Subject: FW: LU/139/19/PL - Rear of 16 and 17 Granary Wall, Toddington Lane, Littlehampton

The LPA would prefer a grass verge rather than paving to the south of the retaining wall to the rear of 16 and 17 Granary Wall, Toddington Lane, Littlehampton (LU/139/19/PL). It is considered that a grass verge would be more appropriate than paving given that there will still be grass verge as you go round the corner and that there is landscaping on the other side.

Status		CONSTRUCTION	
Date	APRIL 2018	Scale	1:50 @ A1
Drawn by	TZ	Approved	
Client Ref.	886	Project Ref.	OP1314
Drawing Number	OP1314/403		Revision
			-

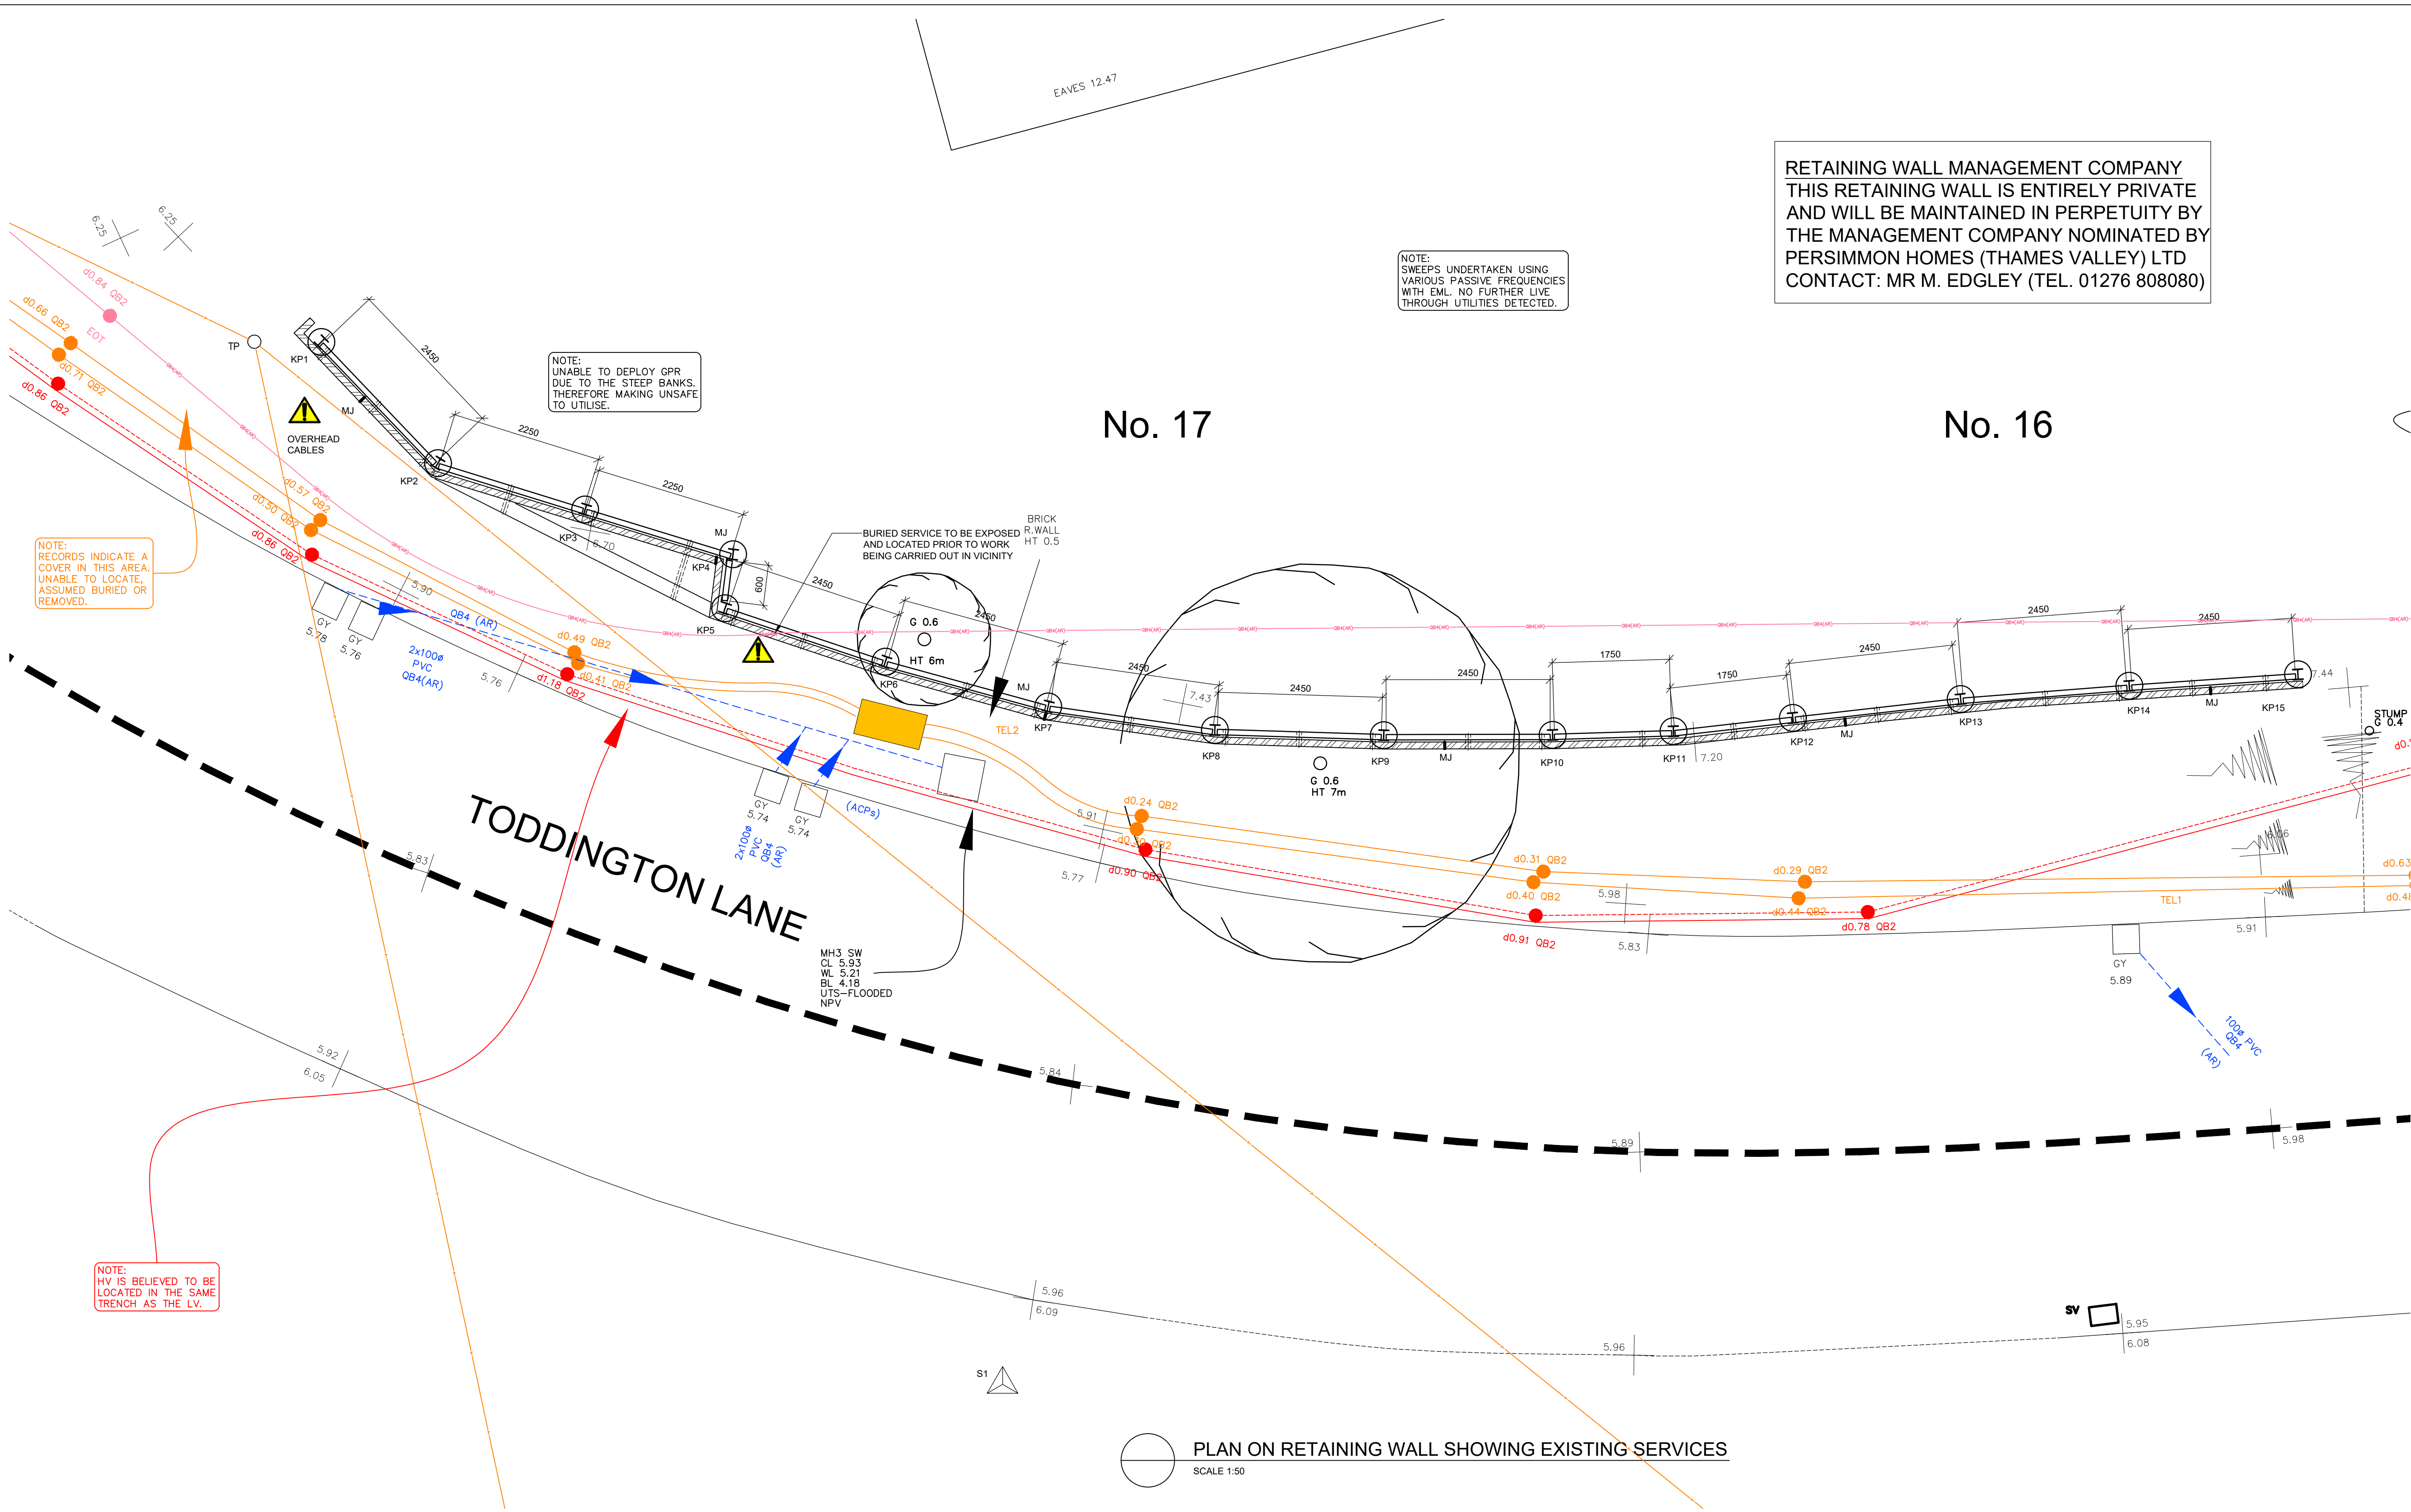
I understand that WSCC requested the paving because of ease of maintenance. I know that the proposals have been through your AIP process with structures/highways, but would you insist on paving rather than a grass verge?

He has advised that the County Council would not wish the area to the front to be verge due to the maintenance liability and the health and safety risk associated with this.

Unfortunately I have been advised by the developer that the retaining wall is needed asap as there is a risk of the current bank falling within the highway if there is any heavy rain.
